WEST SUSSEX COUNTY COUNCIL CONSULTATION

TO:	Arun District Council - FAO: Anita Gardner
FROM:	WSCC - Highways Authority
DATE:	24 May 2021
LOCATION:	Land rear of Paynters Croft, Burndell Road, Yapton, BN18 0HR
SUBJECT:	F/5/21/PL Erection of 23 No. dwellings. This application is a Departure from the Development Plan & is in CIL Zone 3 & is CIL Liable as new dwellings.
RECOMMENDATION:	More Information

Drawing Title	Access Swept Path Analysis
---------------	----------------------------

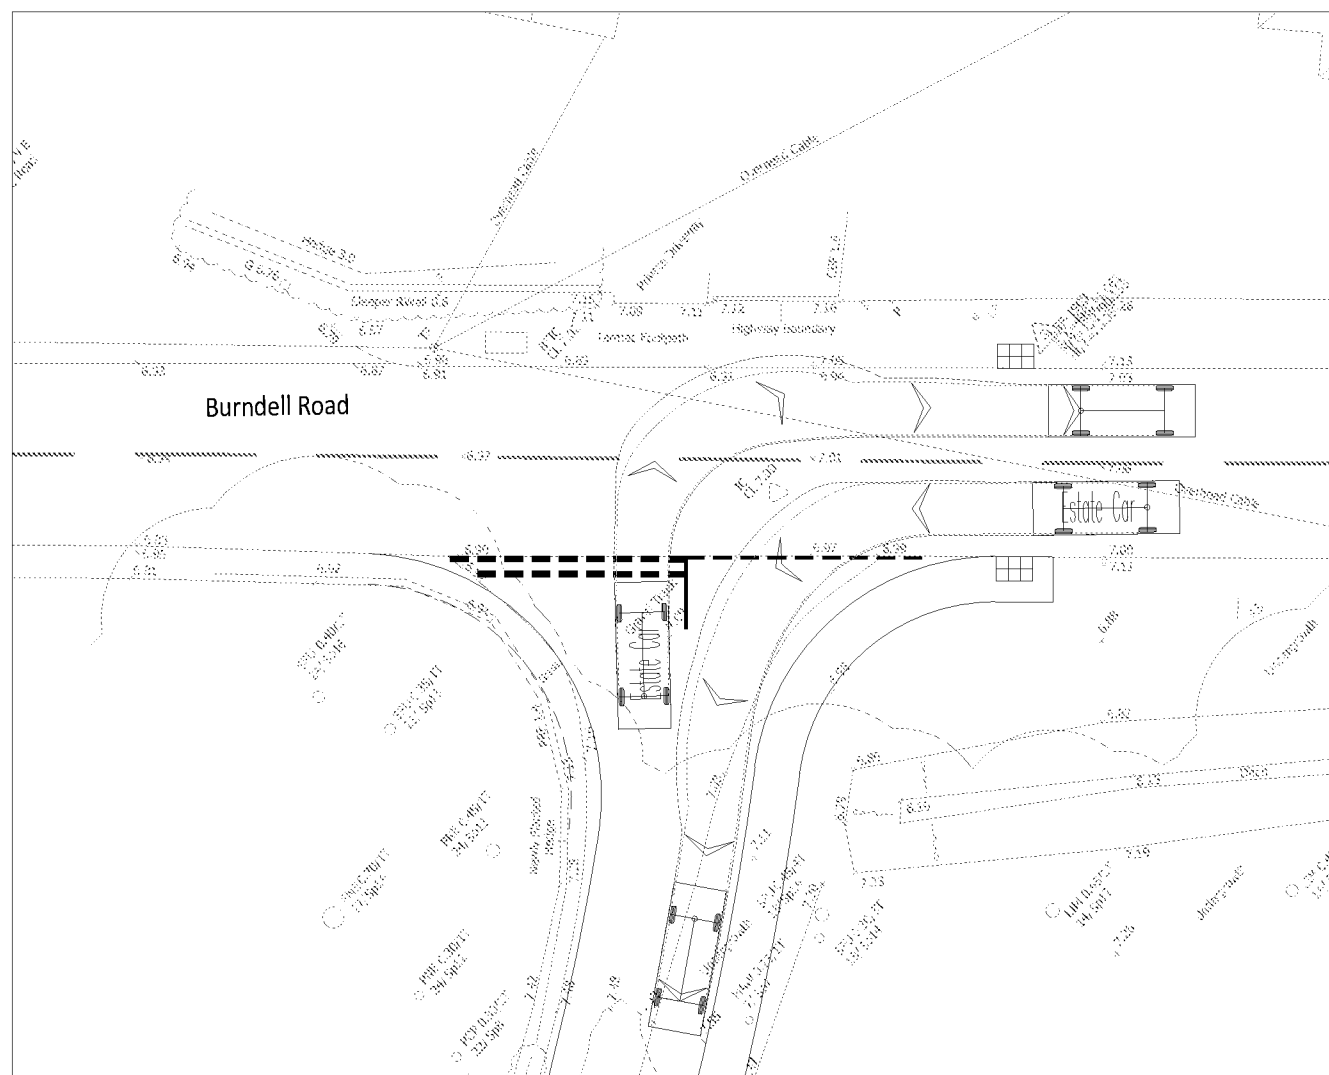
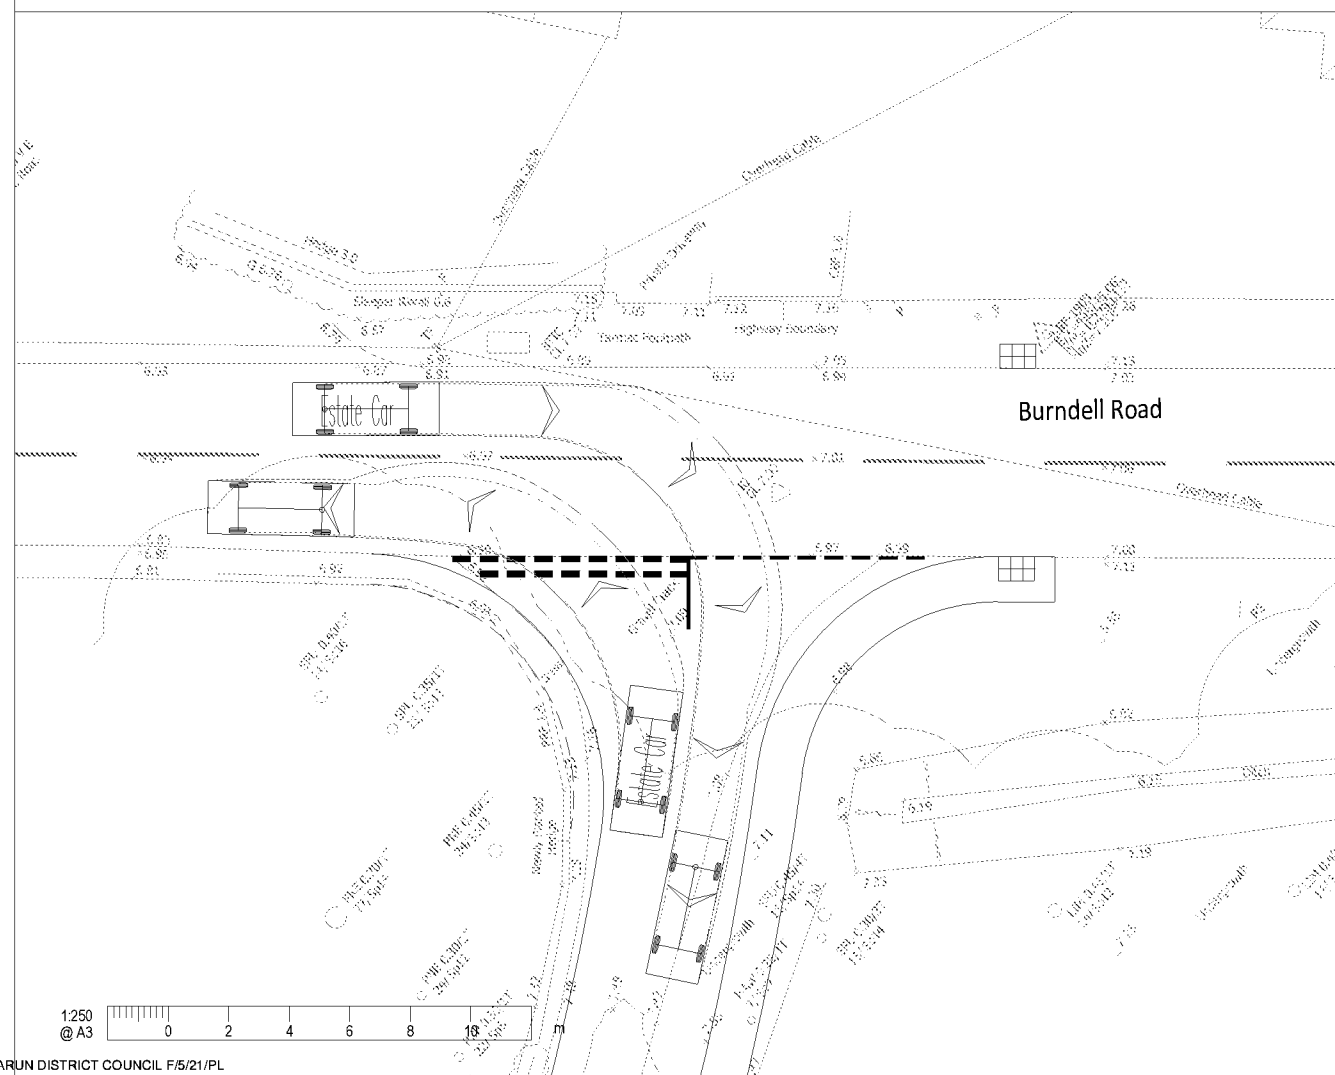
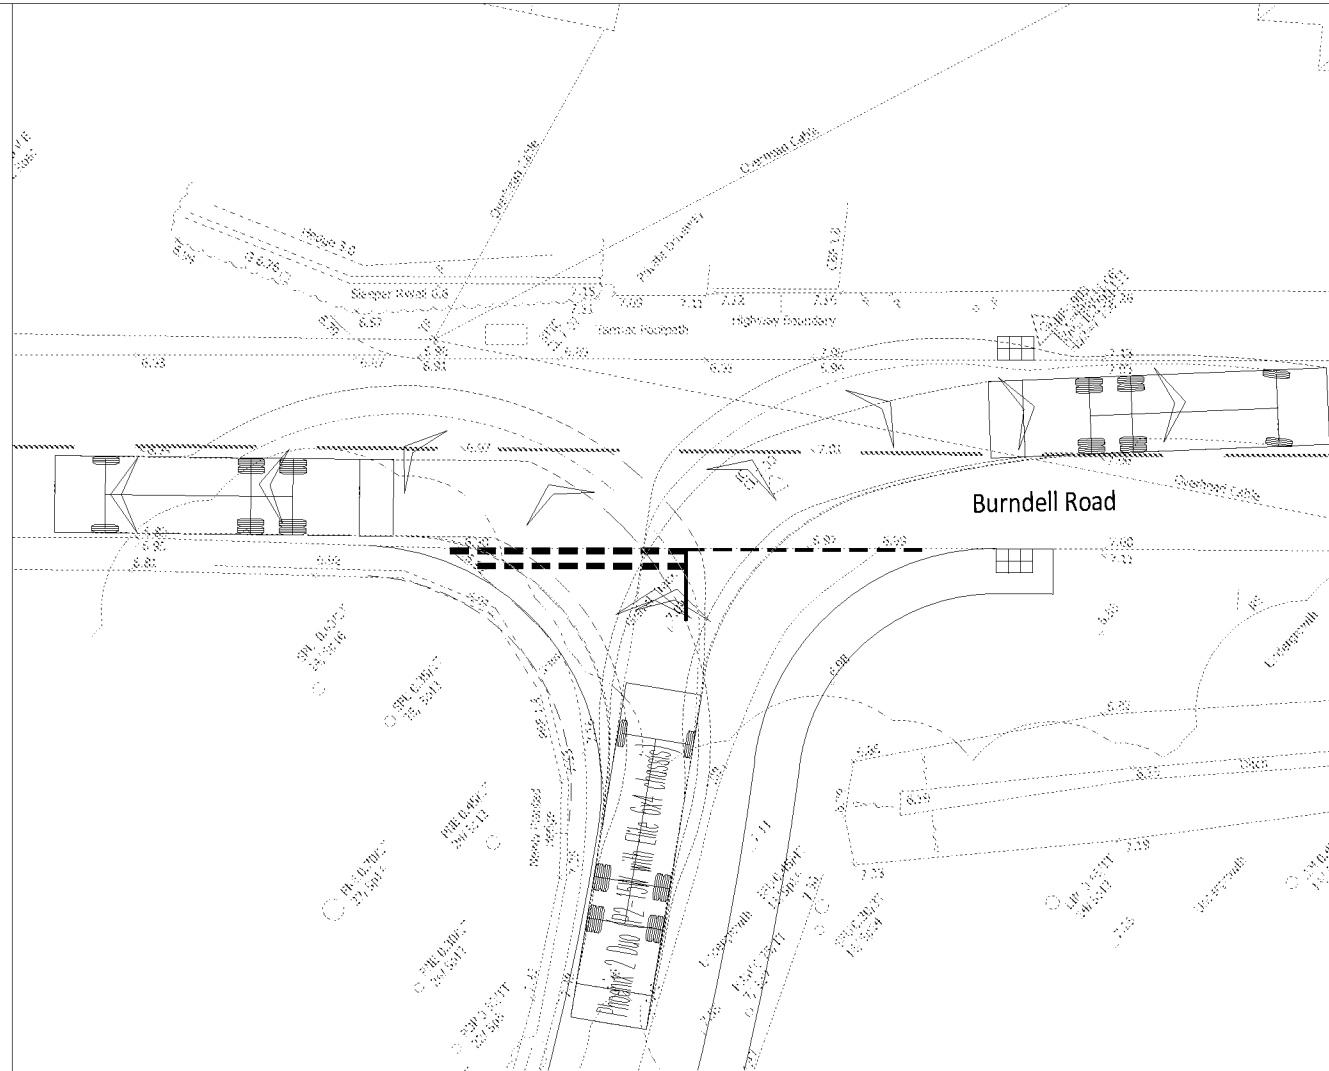
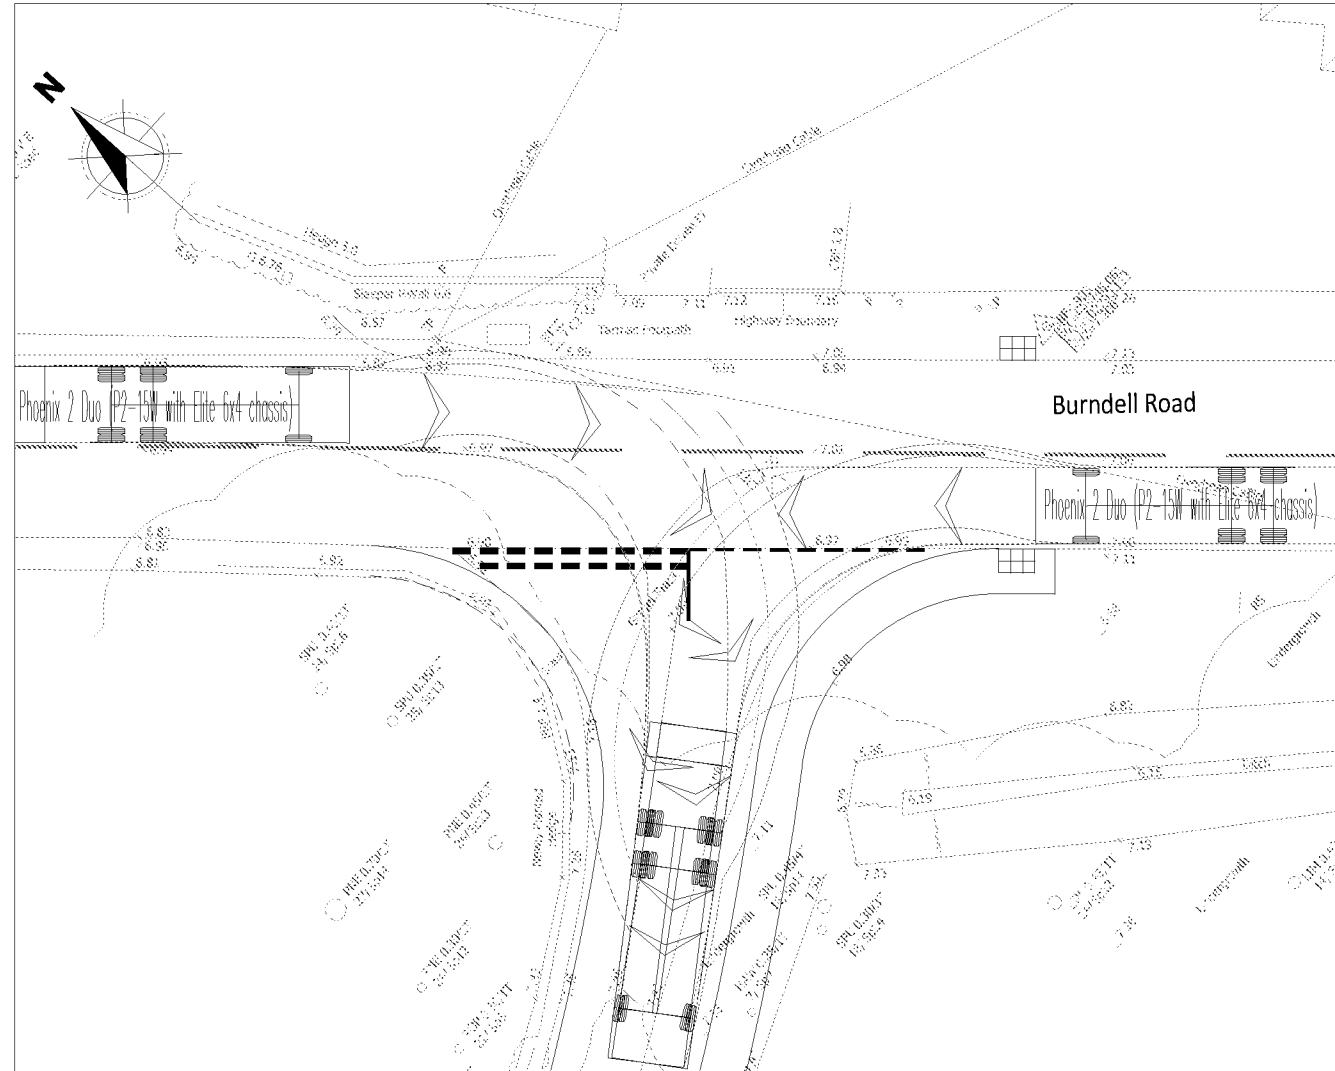
Swept path tracking plans show cars passing in the access and refuse collection vehicle manoeuvring the access point. To reduce vehicle speeds along the 190m long access road, 2 x build-outs are proposed to calm traffic speeds. Tracking plans also show vehicle movement negotiating these priority working arrangements along the access road.
